**Consultation Response from KC,
Lead Local Flood Authority**

2026/91515 Land off Lindley Moor Road, Lindley, Huddersfield, HD3 3SX

Discharge of details reserved by condition 8 (temp drainage) on previous permission 2022/91477 for hybrid application for erection of industrial unit for B2 /B8 use, with ancillary office space and associated access, parking, groundworks and landscaping in conjunction with outline application for mixed use development use class E(b),B2 and B8, with ancillary office space and associated works

Condition 8 – Construction Phase Pollution and Flood Risk Prevention

SITE WIDE DRAINAGE LAYOUT

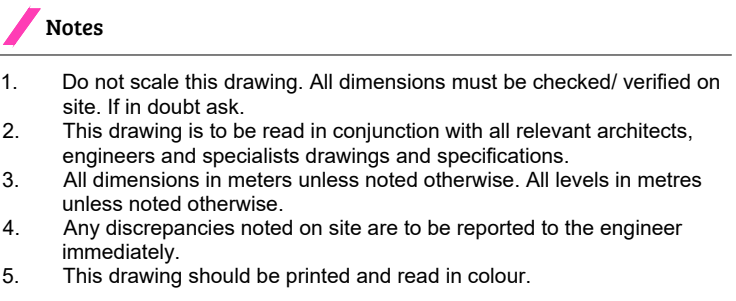
Finally, the drainage plan provided for the developed site with discharge rates less than 3l/s has been rejected.

TEMPORARY SURFACE WATER DRAINAGE LAYOUT FOR CONSTRUCTION STAGE

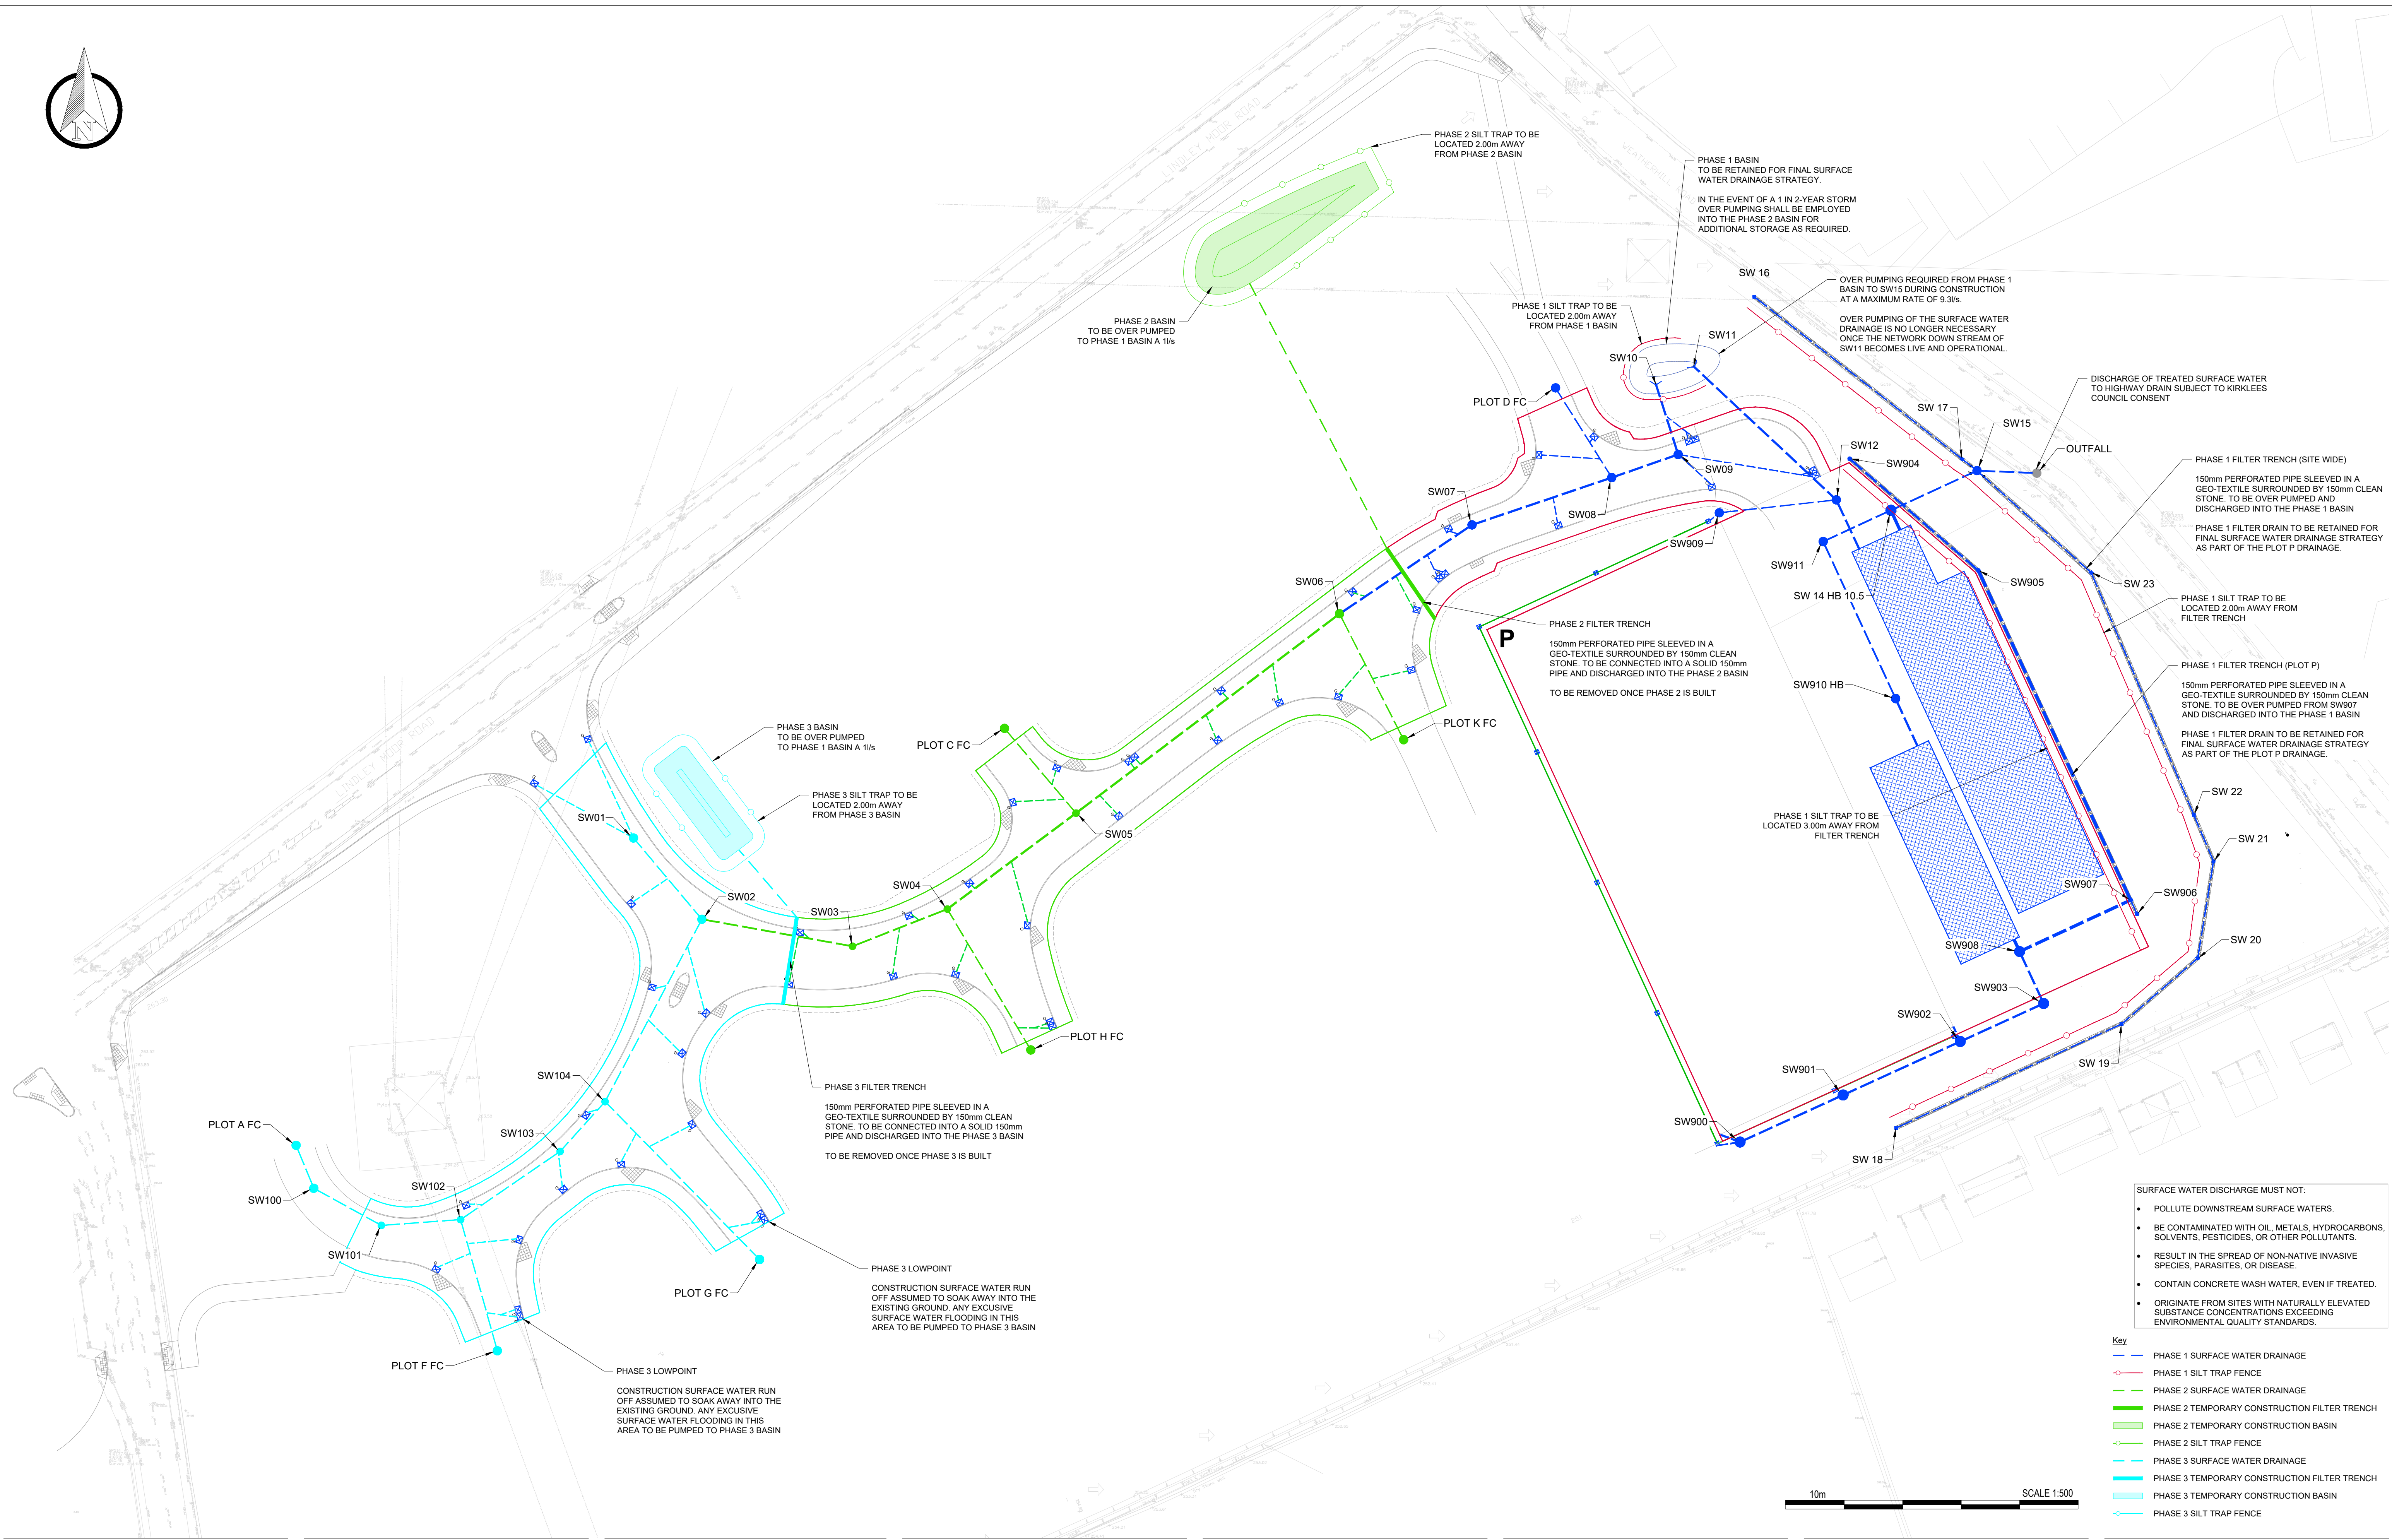
The use of basins and over pumping is noted. Figures for a 1 in 2 storm for the site area must be produced and then shown to be adequate for retaining volume produced for a 6-hour event.

A risk assessment should be provided as part of the assessment. What are the risks? These must include the existing culvert on site that is connected to the land to the east. Whilst we know there is a problem with this culvert beyond Wetherhill Road, contaminated water may still merge and travel overland to pollute local watercourses

There needs to be a back up plan if the sediment does not settle out, for example, flocculation techniques may be used in these circumstances, and beyond this, possible tanker removal. Such actions to reduce risk as necessary ultimately form a method statement.

As the site developments, the points of access to a partly constructed drainage scheme will be a point of concern. Road sweeping, wheel washing, gully and manhole protection. Bungs in outlets etc.

Limiting the soil strip for the early phases and intercepting clean run off and bypassing excavated areas is a useful technique in controlling volumes of polluted water. This will mean lower volumes are tackled.
